ALUMNI HALL
RENOVATION

STAIR PLAN

A28
Scale AS NOTED

A28

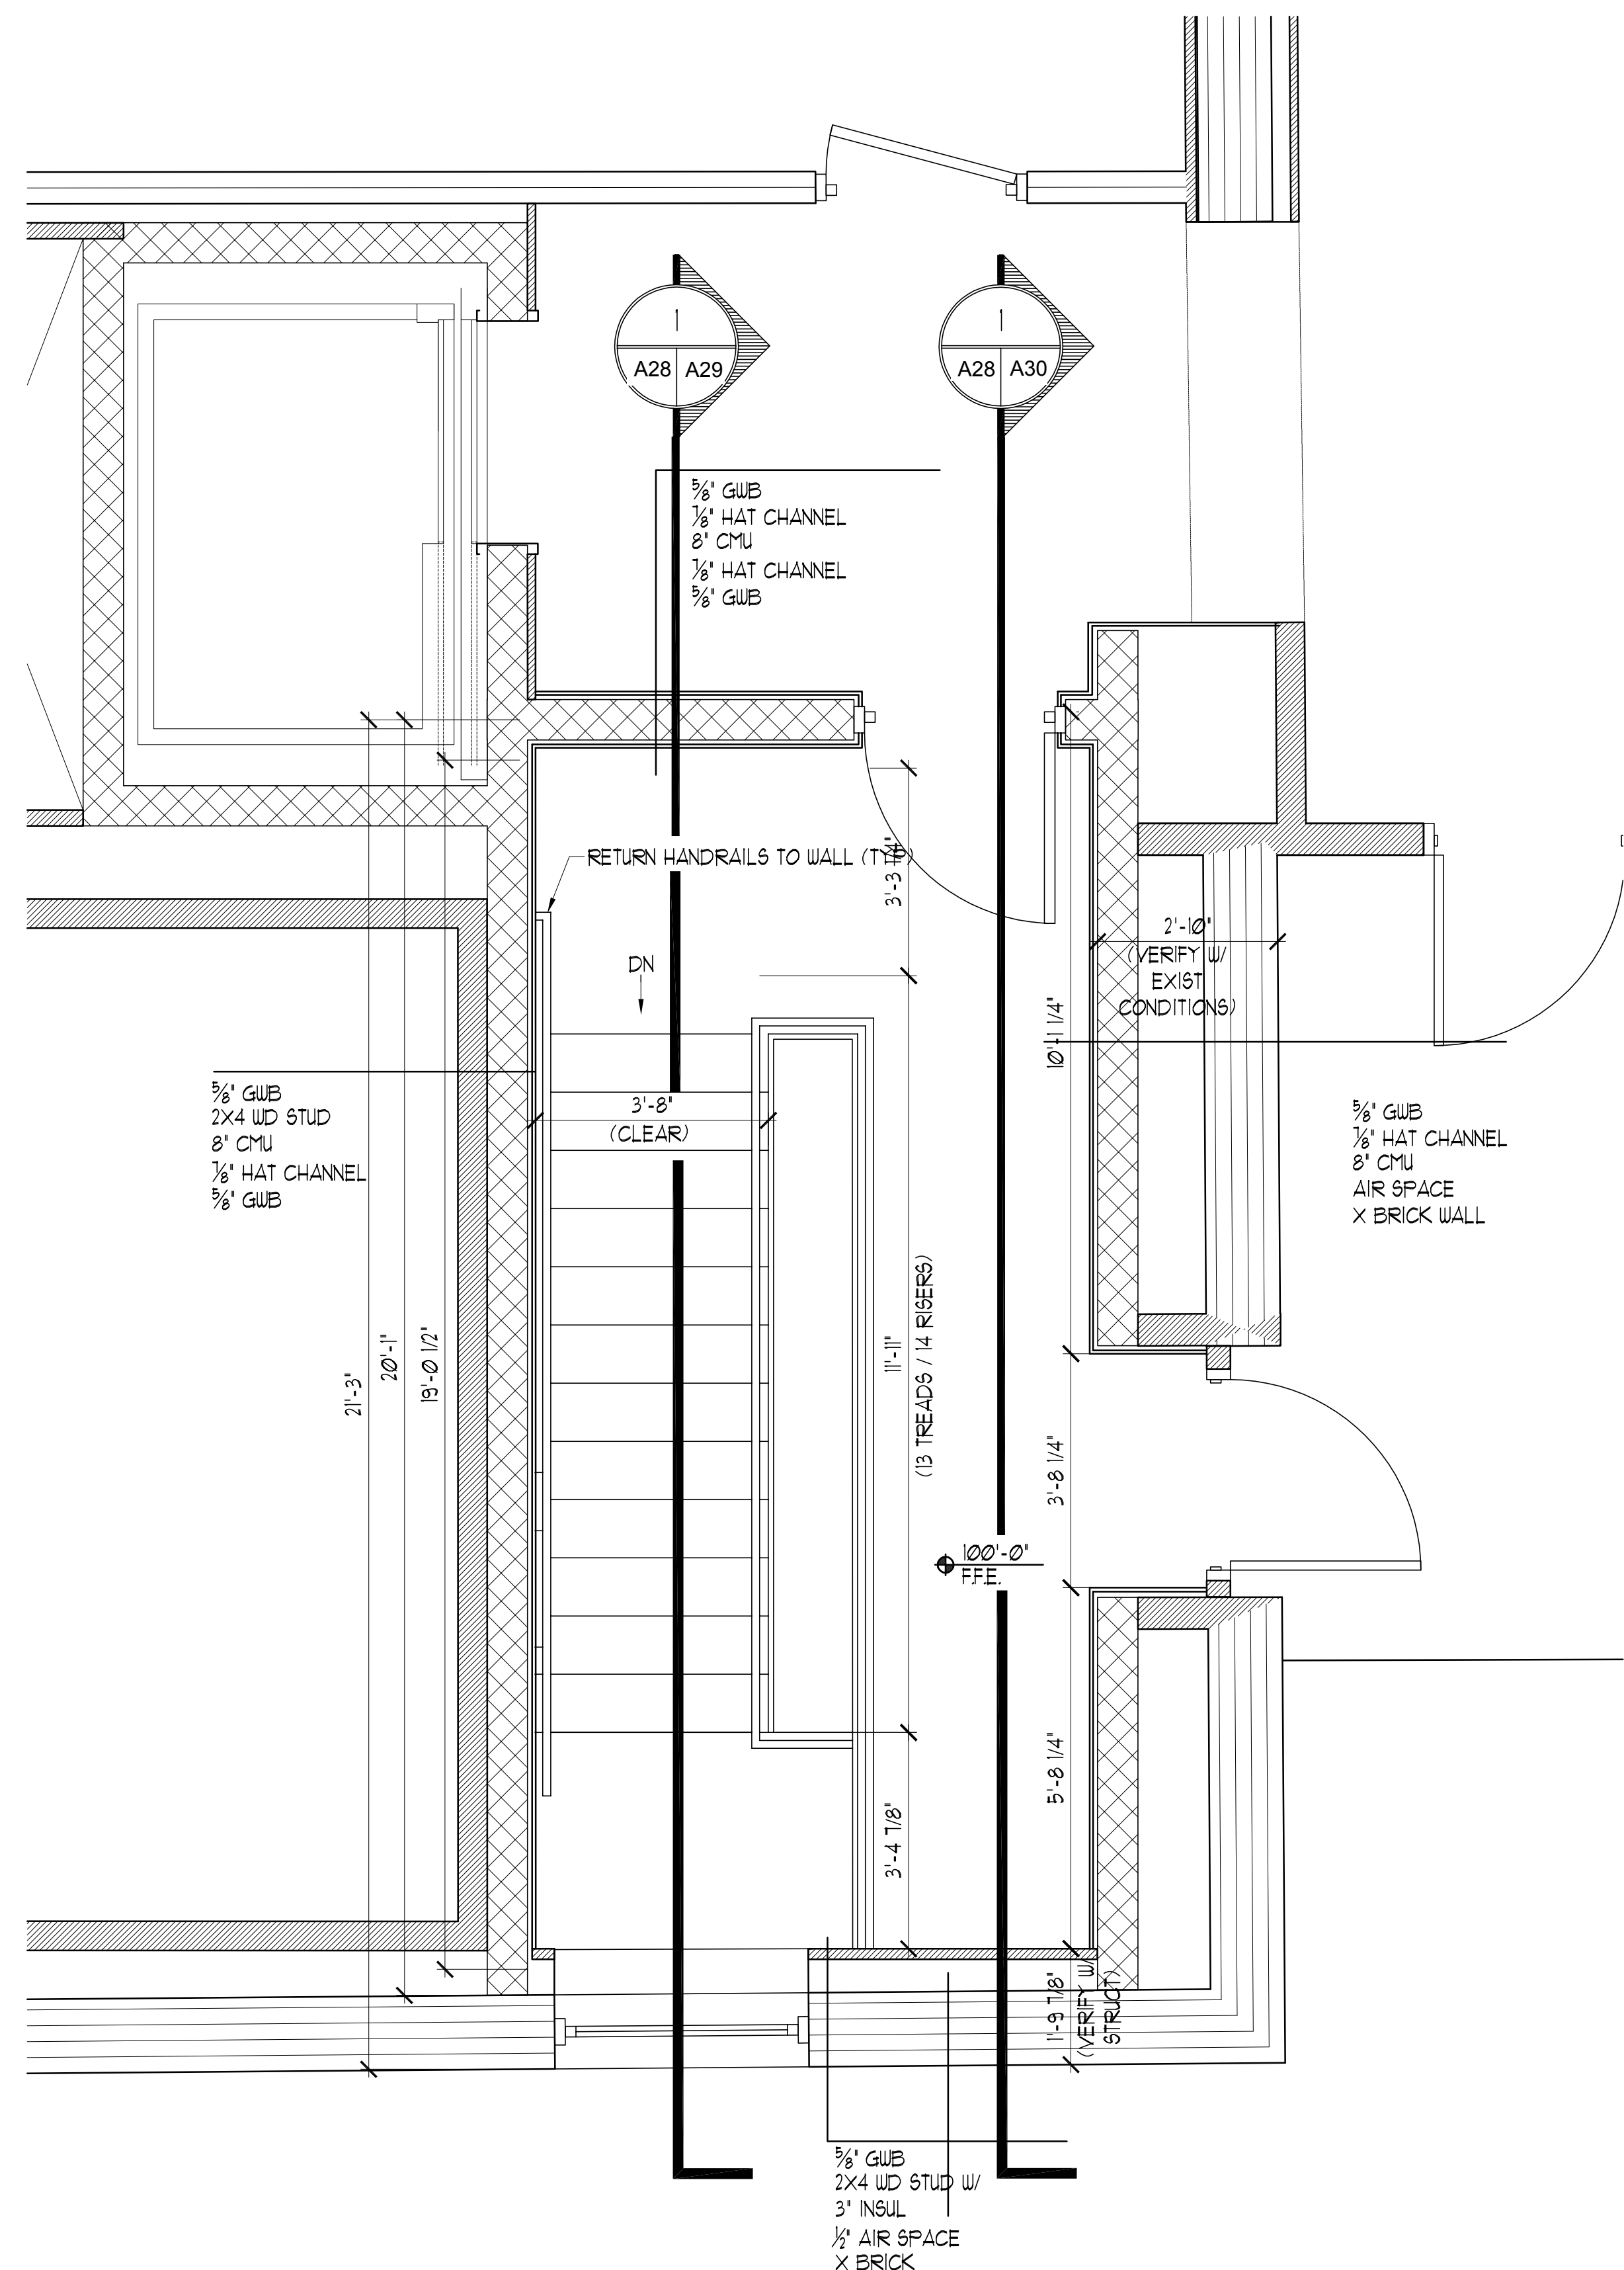
I am not able to find this area on an elevation plan, or details on the window schedule. Will this window be required to be tempered safety glazing due to the location?
